Town & Country Planning (Control of Advertisement) (England) Regulations 2007 (as amended)

Application for Consent to Display an Advertisement(s)

Development: Installation of 1No. fascia sign.
Location: 17 High Street Bognor Regis PO21 1RJ

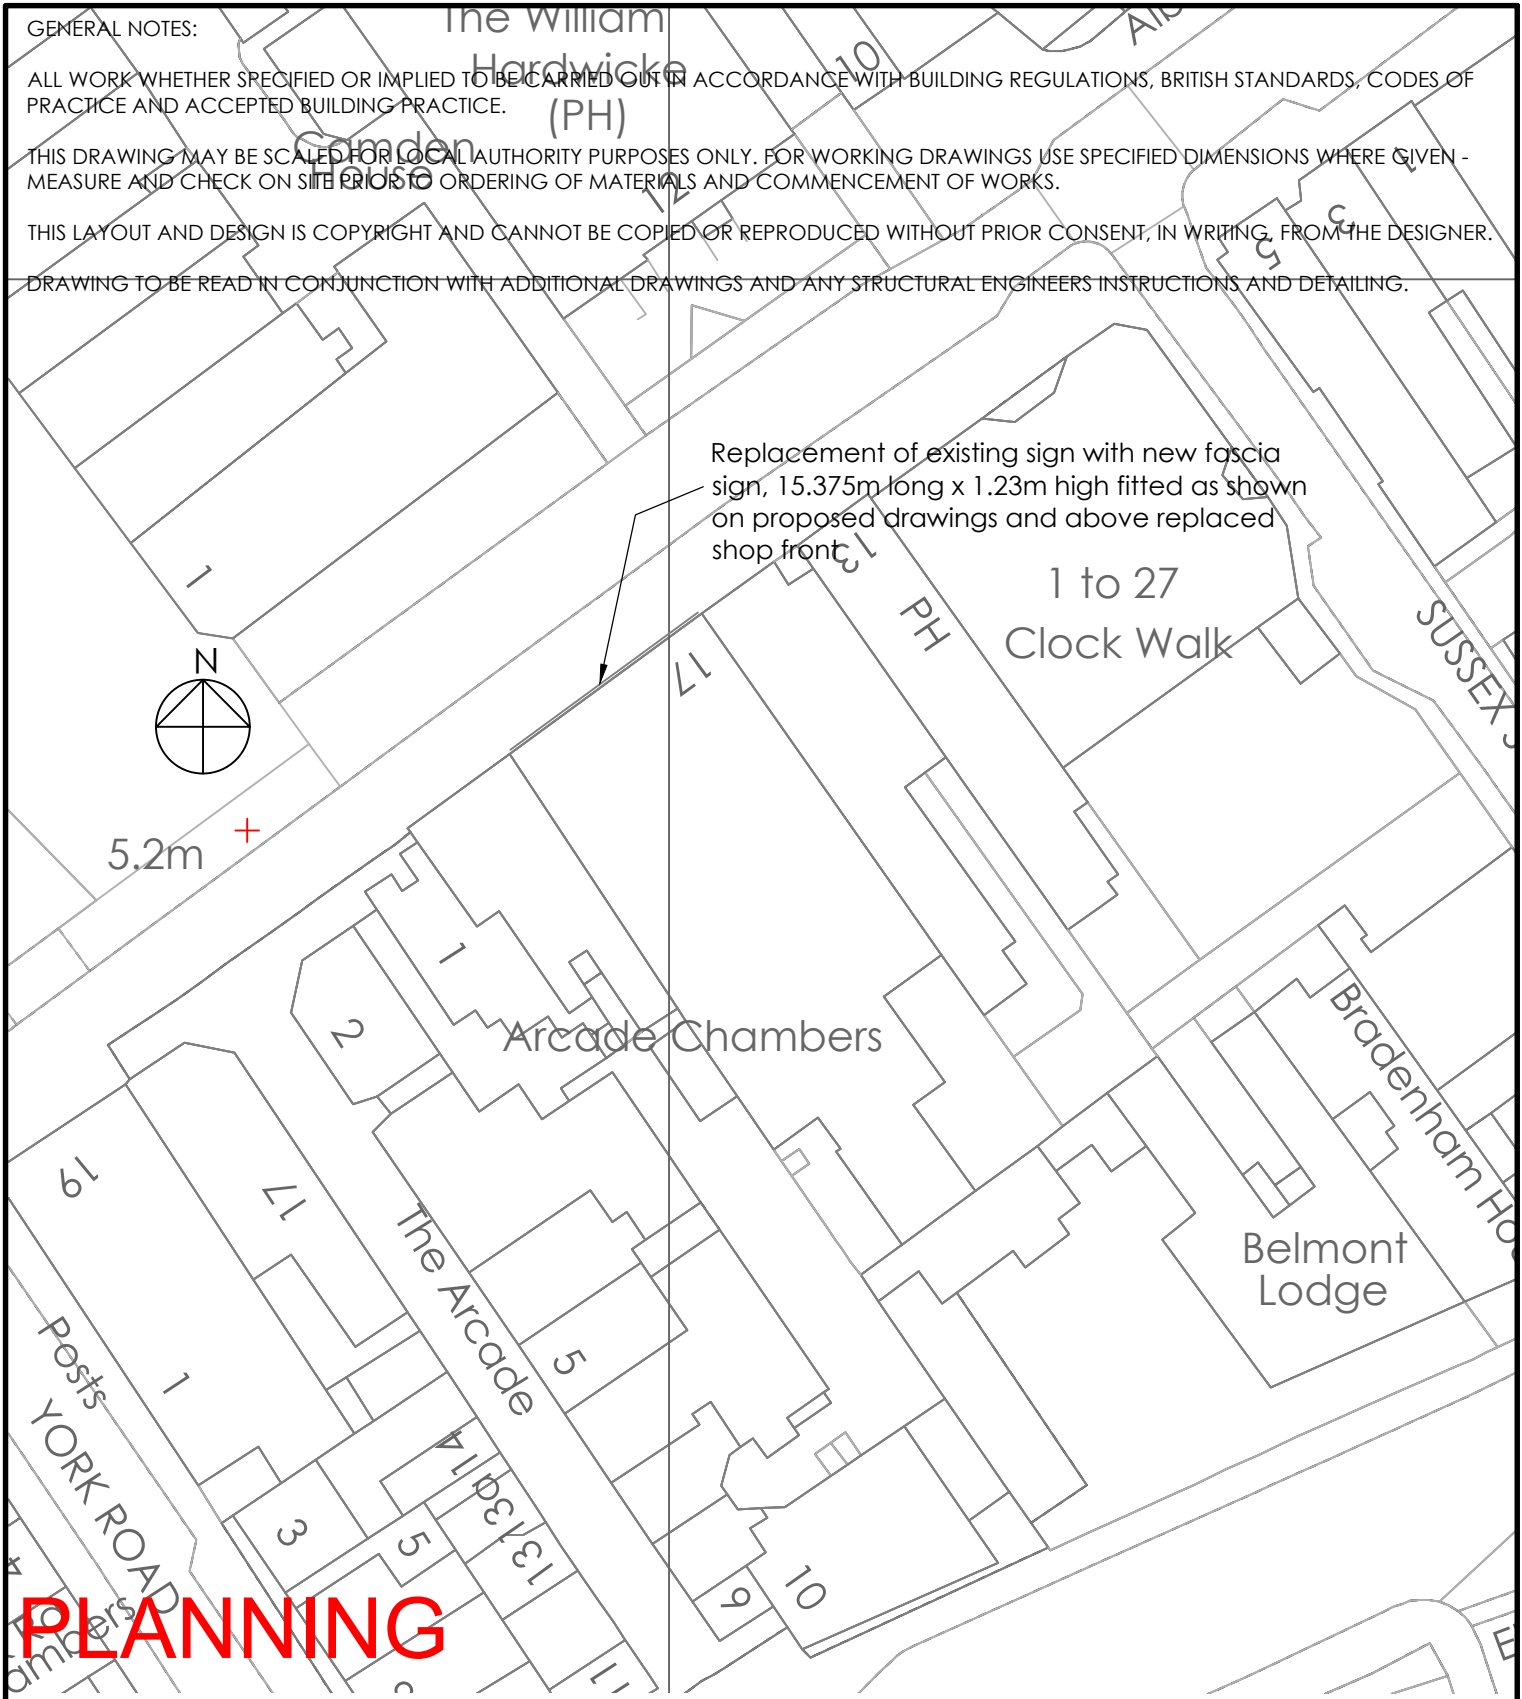
Block Plan

Please submit an electronic block plan showing the location of the proposed signage in pdf format at a scale of 1:500. Further details of what must be included on the plan can be found in the Validation Requirements List.
